Rezoning Transportation Analysis

Petition Number: 2022-145

Date	Description
1-25-23	First Review (IW)

Rezoning Transportation Analysis

SHEET NUMBER
RZ-1

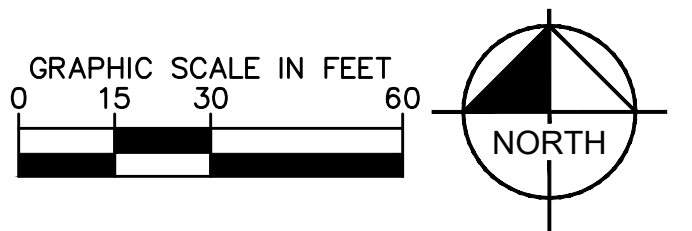
1. Curblines:

- a. **Robinson Church Road:** Location of future curb and gutter to be 19 feet from roadway centerline to accommodate the Charlotte Streets Map with a roadway typical section of CLDSM 11.09 Minor Thoroughfare.
- b. **Harrisburg Road:** Location of future curb and gutter to be 30 feet from roadway centerline to accommodate the Charlotte Streets Map with a roadway typical section of CLDSM 11.09 Major Thoroughfare.

Label and dimension the curb and gutter from the centerline for each road on the site plan.

3. Revise site plan and conditional note(s) to commit to dedicate 41 feet of right-of-way from the Robinson Church Road centerline and 52 feet of right-of-way from the Harrisburg Road centerline. The site plan shall label and dimension the right-of-way from the road centerline.
4. Revise site plan and conditional note(s) to commit to construct an 8-foot planting strip, and 12-foot multi-use path on Robinson Church per Chapter 19, to support the future council adopted Charlotte Streets Map, and to meet the Council-adopted Charlotte BIKES Policy. Multi-use paths shall meet ADA/PROWAG requirements. The site plan shall label and dimension both items from the back of curb and gutter or edge of pavement.

5. Revise site plan and conditional note(s) to commit to construct an 8-foot planting strip, and 12-foot multi-use path on Harrisburg Road per Chapter 19, to support the future council adopted Charlotte Streets Map, and to meet the Council-adopted Charlotte BIKES Policy. Multi-use paths shall meet ADA/PROWAG requirements. The site plan shall label and dimension both items from the back of curb and gutter or edge of pavement.

7. Revise site plan to move driveway on Robinson Church Road as close to property line as possible to create more space from the existing signalized intersection per coordination with NCDOT.
